**Subject: MISC/259/2018/B - Mandalong Southern Extension Project - Modification
8 – Response to Submissions**

12 Kerry Anderson Drive, MANDALONG NSW 2264

Figure 6 | Conceptual layout of the proposed carpark

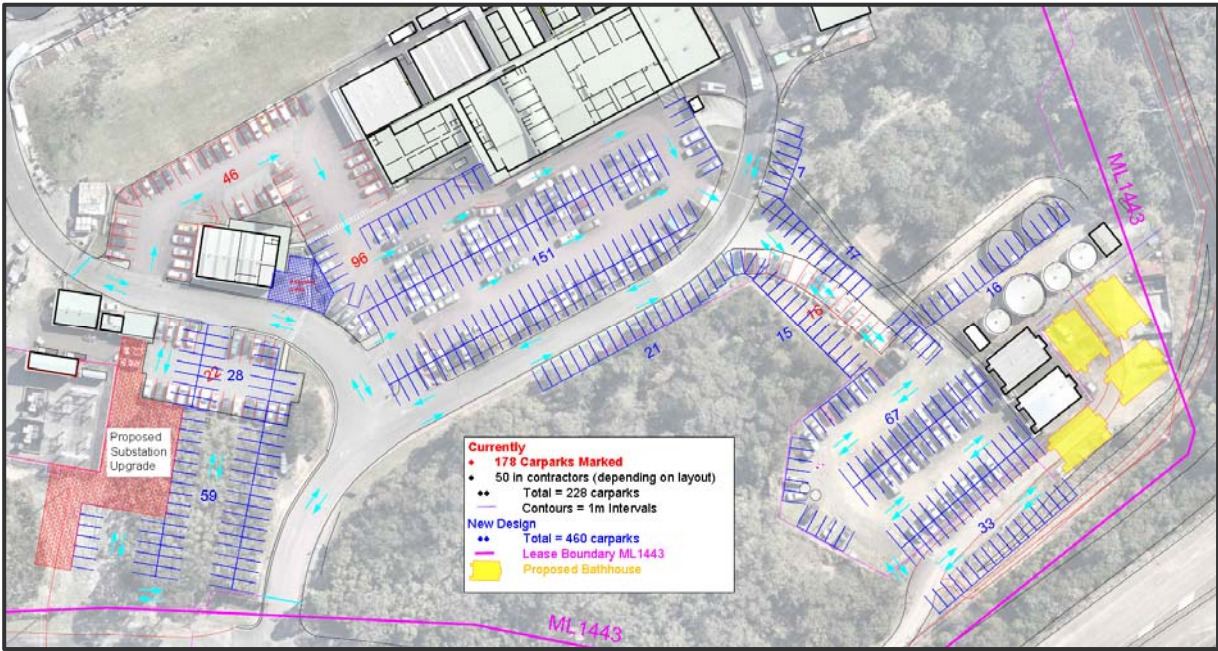
- Council is satisfied that the proposed car parking will be appropriately located and designed, and that existing management practices will be amended to encompass the additional hardstand areas. Council request that it be clearly annotated on the plans that all new car parking areas shall comply with Australian Standard 2890;

- The removal of the vegetation and replacement with a landscape buffer is supported however, the location of the proposed buffer is on Council property which is not supported. The proposed buffer also does not sufficiently obscure the proposed car parking from Mandalong Road. It is requested that a more substantial vegetation buffer be implemented within Centennial owned land to address the visual amenity issue for traffic traveling along Mandalong Road to the proposed new car parking area.
